Development Control
Arun District Council
Arun Civic Centre
Maltravers Road
Littlehampton
BN17 5LF

20th January, 2018

Re:- Planning Application R/285/17/HH – 89 Broadmark Lane, Rustington, BN16 2JA

Proposed Elevations scale: 1/100

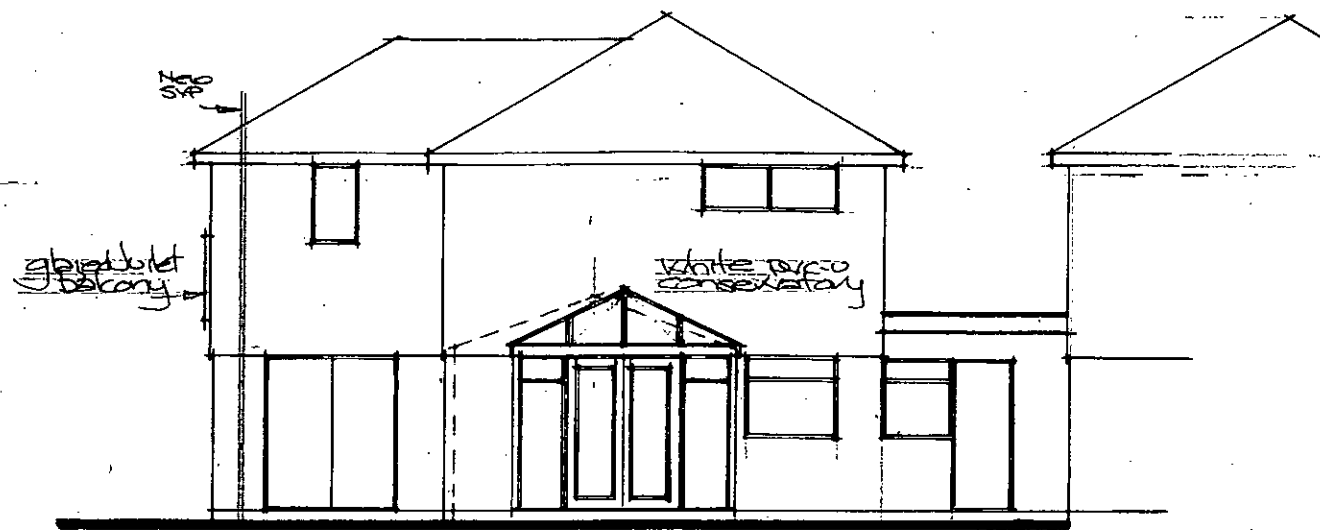
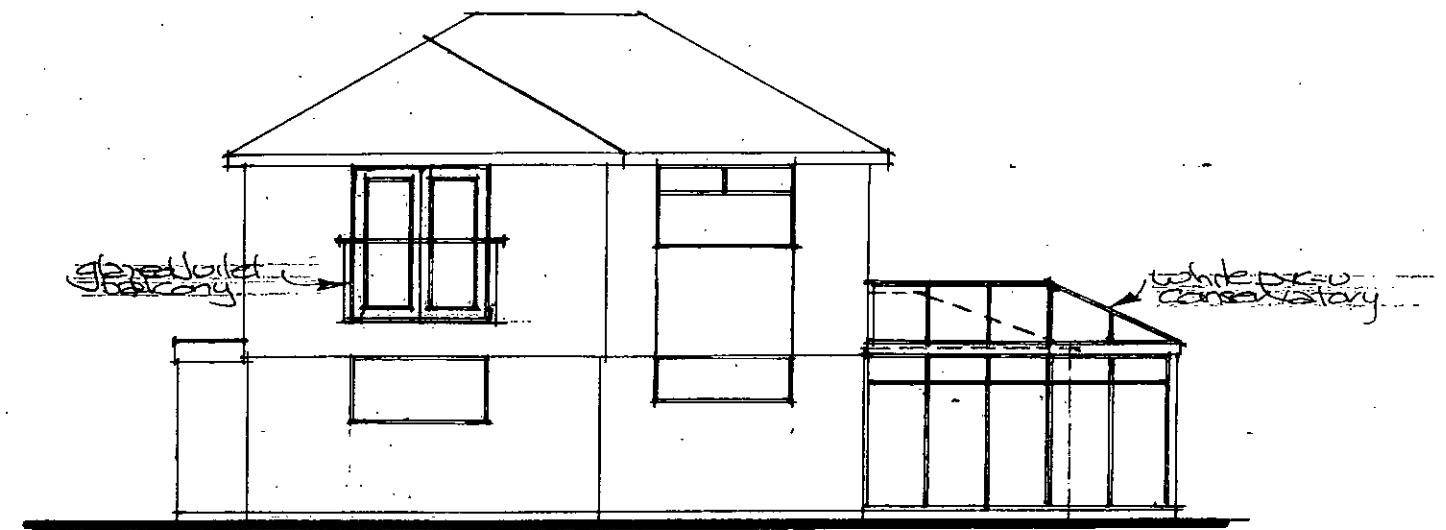
On the plan provided by the Architect there is insufficient detail regarding weather proofing and sound proofing to the party wall nor to the front elevation of the raised garage roof. Our living and dining rooms are next to the party wall with number 89. Our main concern is the possibility of unacceptable noise from washing machines, dishwashers etc., Because of the proposed raised ceiling height of the garage this could also impact on our two first floor bedrooms.

As mentioned in our letter dated 20th December 2017 weather tightness to the party wall is obviously very important – we do not want rainwater penetration causing dampness to our house. Bearing in mind the closeness to the sea and the prevailing wind and rain, suitable flashings and detailing are vital, as is surface water drainage from the flat roofs.

We have been sent a copy of proposals by Mr and Mrs Gale's Architect Paul Trussler to extend and alter this adjacent house. Our two main concerns are soundproofing and guaranteed weather proofing to the party wall. There is also no detail as to the elevation materials to the raised garage roof (as seen from the road).
